Subject: Planning ref: 19/01037/REM. OS Parcels 6741 and 5426 West of Cricket Field and North of Wykham Lane Bodicote.

Crime Prevention Design Advisor | Oxfordshire | Local Policing | Thames Valley Police

Drawing Title
HARD, BOUNDARY & FURNITURE PROPOSALS (SHEET 2 OF 3)

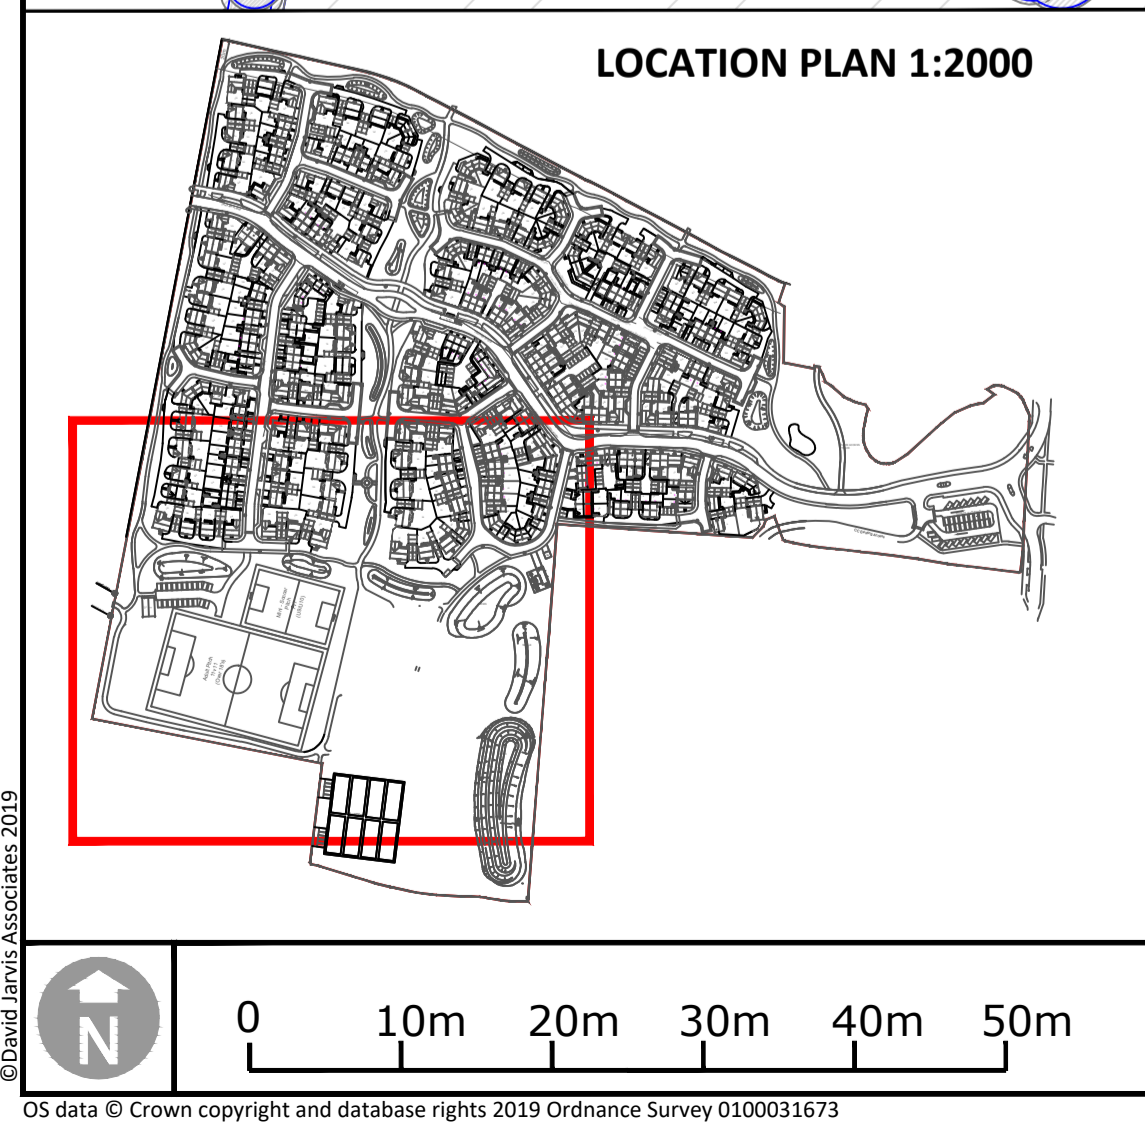
- The landscaping scheme should ensure that natural surveillance throughout the development and to/from units is not compromised. I am concerned that some trees/hedges may impinge upon this in future. Tree positions and final growth height/spread should be carefully considered and hedge heights should be maintained at no more than 1m.

I also recommend that there is no hedge provided at the southern LAP/LEAP as this will remove the chance of it not being maintained at an appropriate height. It is also proposed that some hedges will be maintained at 1.8m. This is not acceptable in situations where it could impinge upon natural surveillance.

- The landscaping scheme and maintenance plan require careful consideration to ensure that areas of ambiguous ownership are not created. Measures to prevent vehicle intrusion on to any segregated pedestrian routes and public open spaces must also be provided.

- Where boundary treatments of private rear gardens abut public or semi-private space they should incorporate features that make them difficult to climb; trellis on fences, angled or rounded copings on walls etc. All access gates to rear gardens (including communal ones) should be; robust, of the same height as boundary treatments, self-closing, have anti-lift hinges and be key operated from both sides. Also, some gates to rear gardens are not provided as close to the front building line as possible, which creates problematic recesses. I would like to see them brought forward wherever possible. And, I note that the DAS states that 'Hit and miss' fencing will be used to provide oversight of parking to the rear of properties. However, the Enclosure Plan shows no such fencing. The proposed visually permeable treatment should be used where possible and appropriate.
